Immingham Eastern Ro-Ro Terminal (“IERRT”)

PINS Ref: TR030007

Deadline 7 submissions of the IOT Operators

8.3.3      Figure 3.1      Demolition works associated with Immingham Eastern  
Ro-Ro Terminal

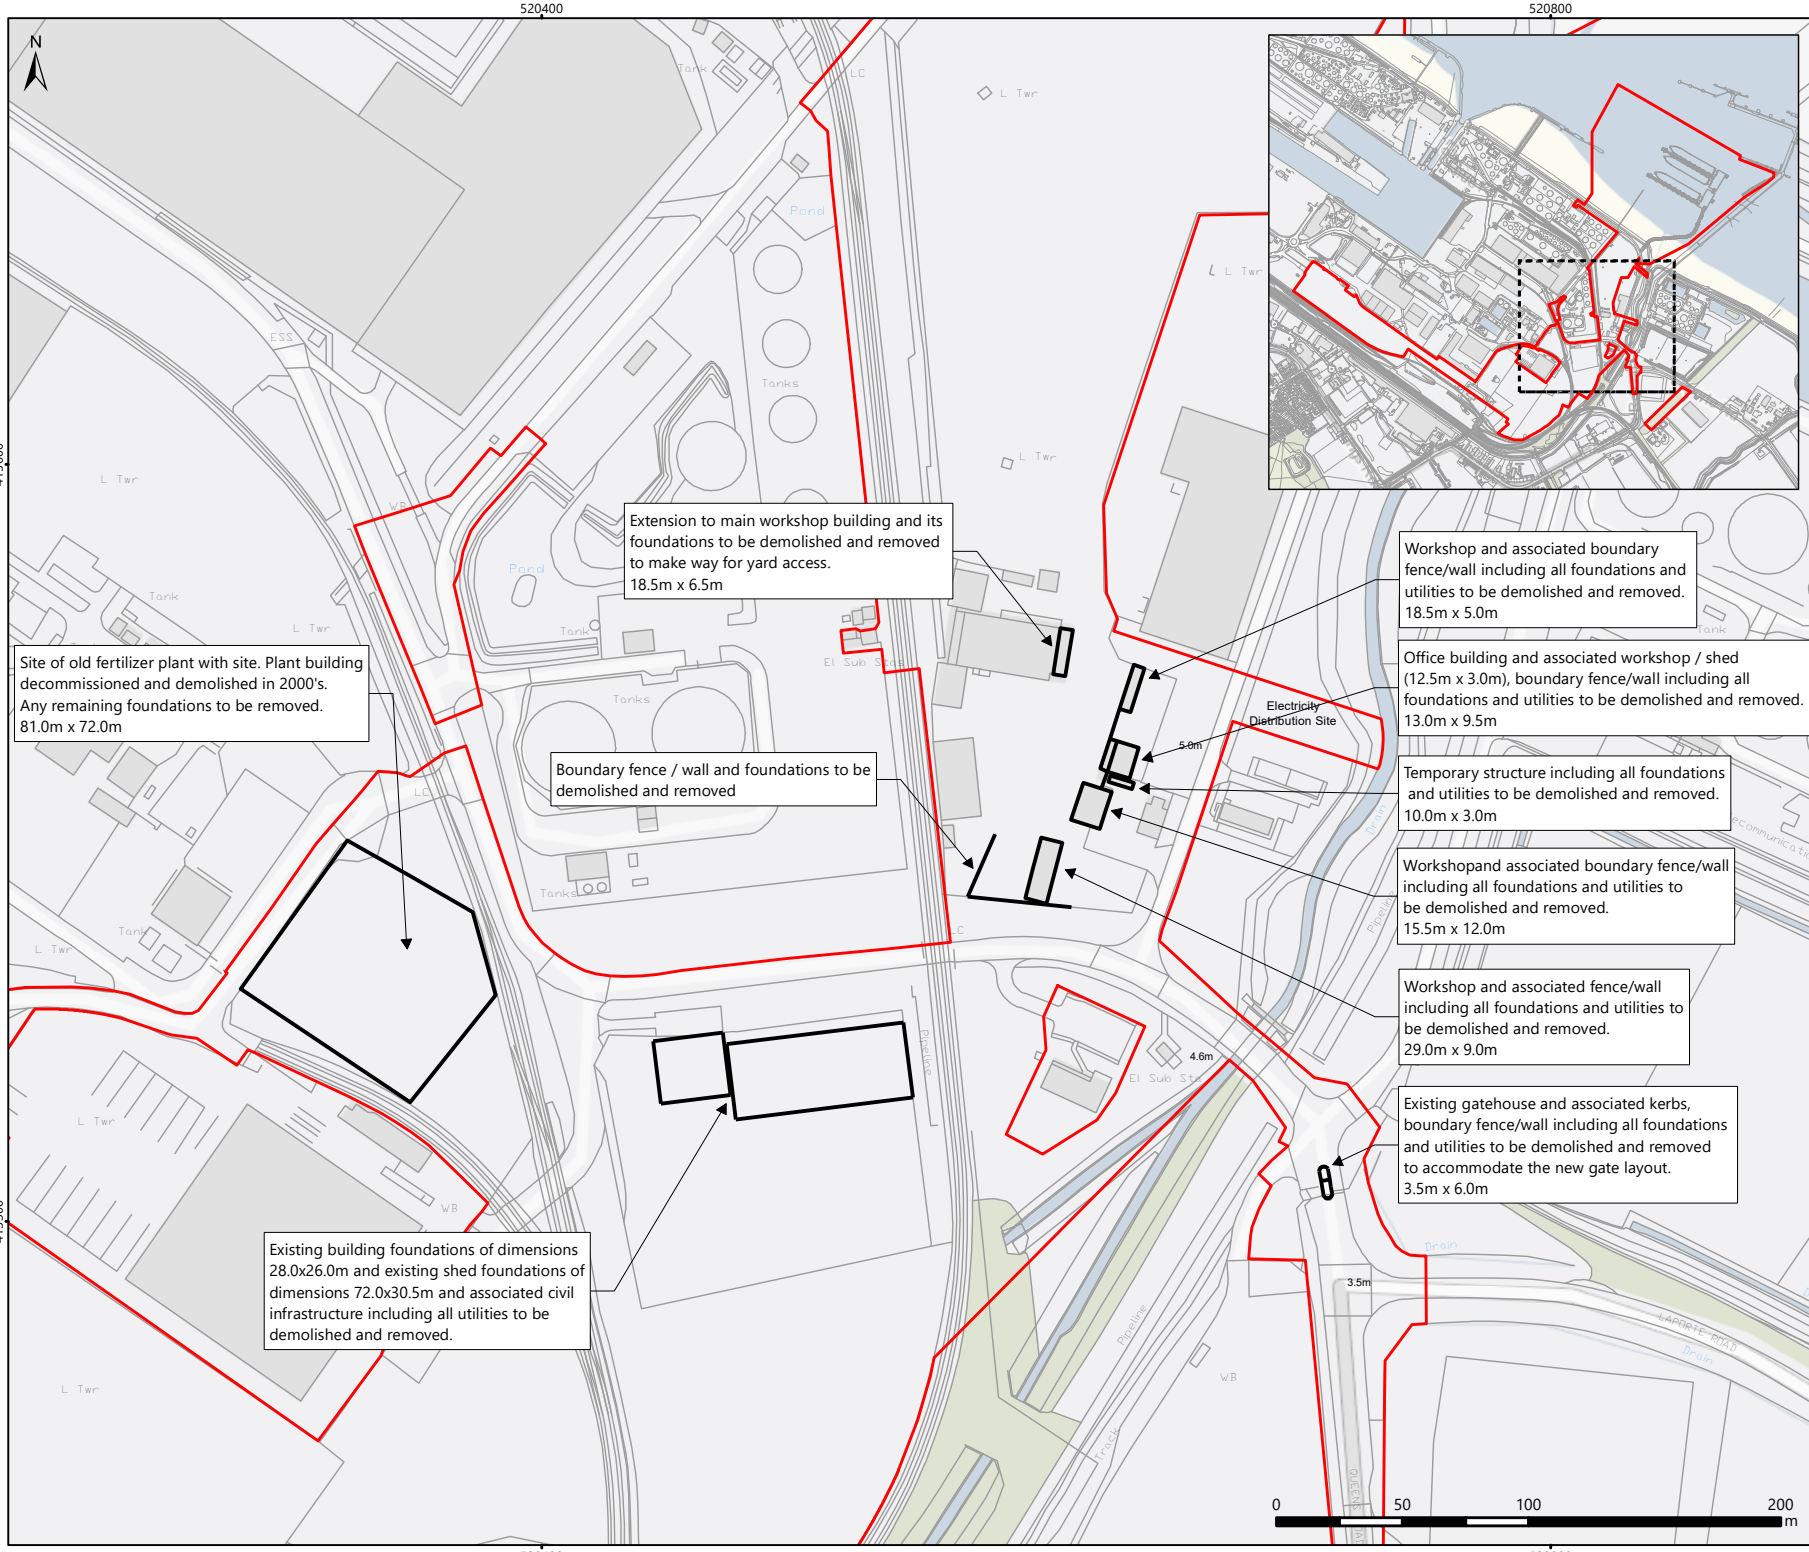
56. However, the ES has simply failed to assess the impact of the design vessel: see ES Chap 3 §3.2.5 [APP-039] & [REP 5-036] pp. 9-11 (APT 23.10.23). It has not done what is stated at §10.8.83 i.e.

since it has not assessed the likely significant effects arising from the maximum parameters as stated to be necessary at §§2.3.4-2.3.7 i.e. the design vessel described in §3.2.5.
